RE: Cosme Retail (Central Ave)

Grading and Drainage Plan

Engineer's Stamp Date 3-15-2017 (File: K11D077)

GRADING & DRAINAGE PLAN

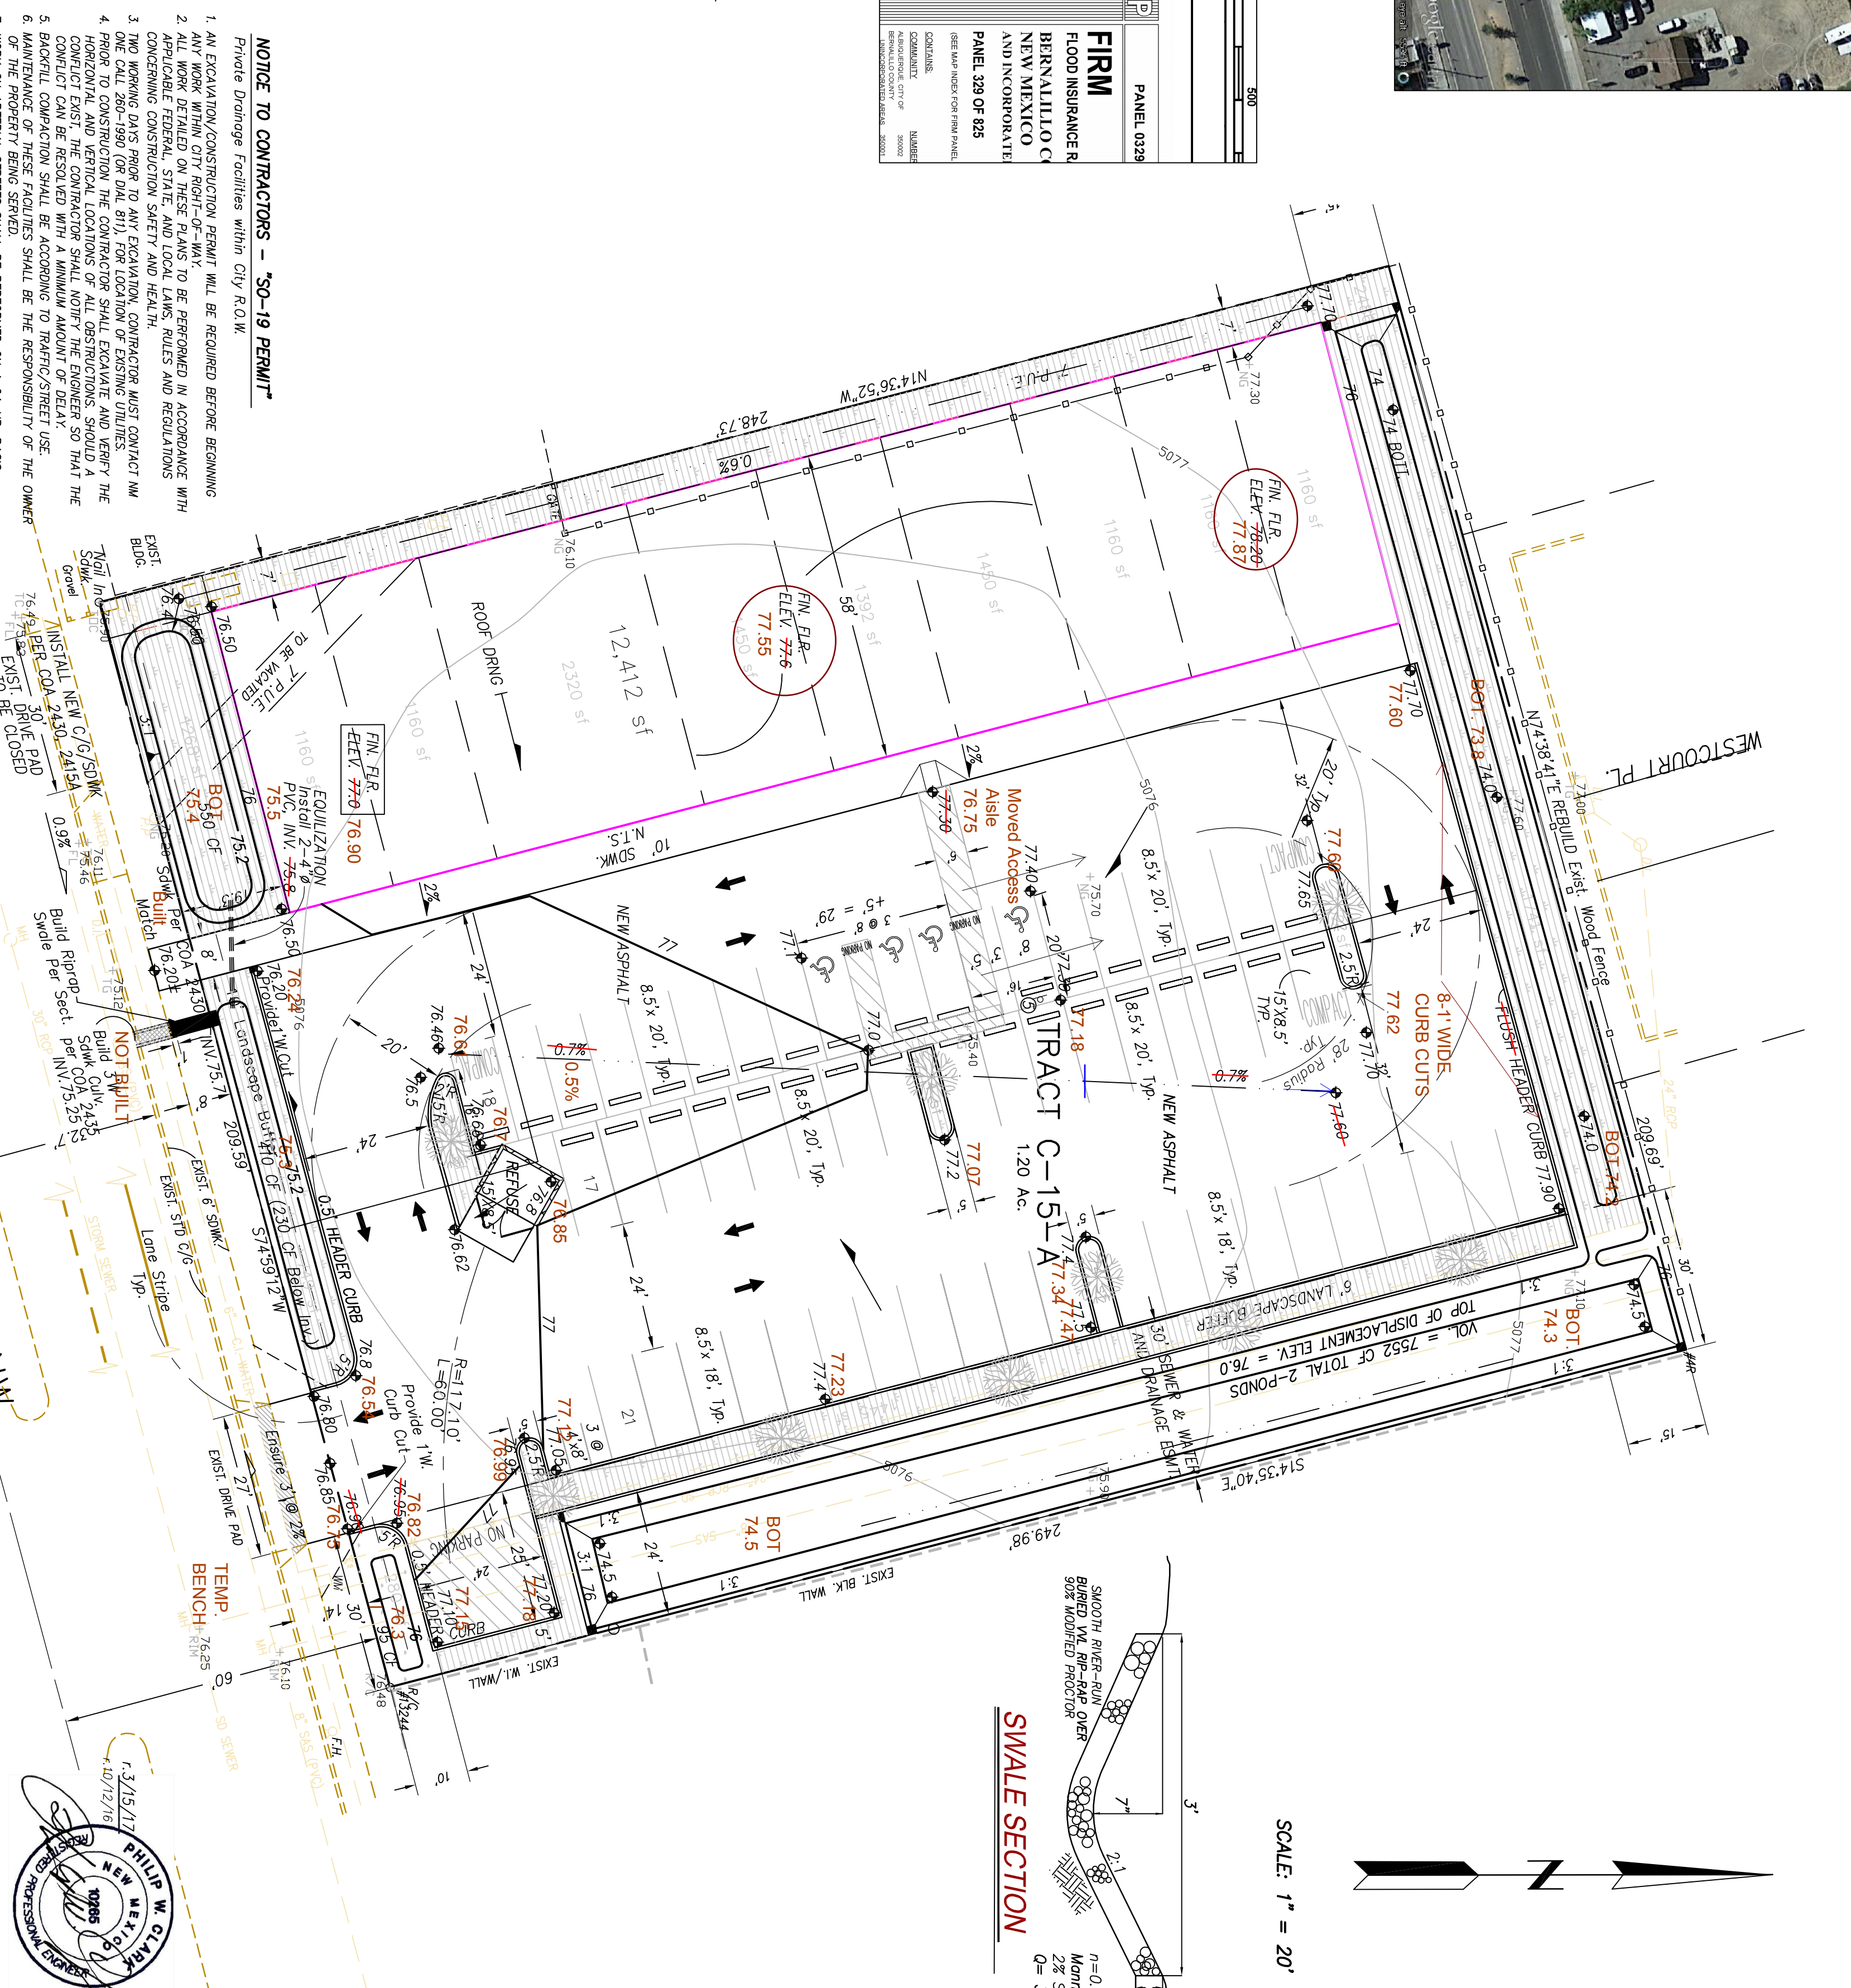
- 2. Provide an outfall/equalization for the larger pond on the southwest corner. A sidewalk culvert between this and the adjacent pond would work. Also, provide a curb cut outfall for the smaller pond on the southeast corner towards the driveway. Although the onsite flows to the ponds is small, the outfalls will help mitigate the SFHA Zone AH hazard by providing an outfall for the base flood.

- 2. Provide an outfall/equalization for the larger pond on the southwest corner. A sidewalk culvert between this and the adjacent pond would work. Also, provide a curb cut outfall for the smaller pond on the southeast corner towards the driveway. Although the onsite flows to the ponds is small, the outfalls will help mitigate the SFHA Zone AH hazard by providing an outfall for the base flood.
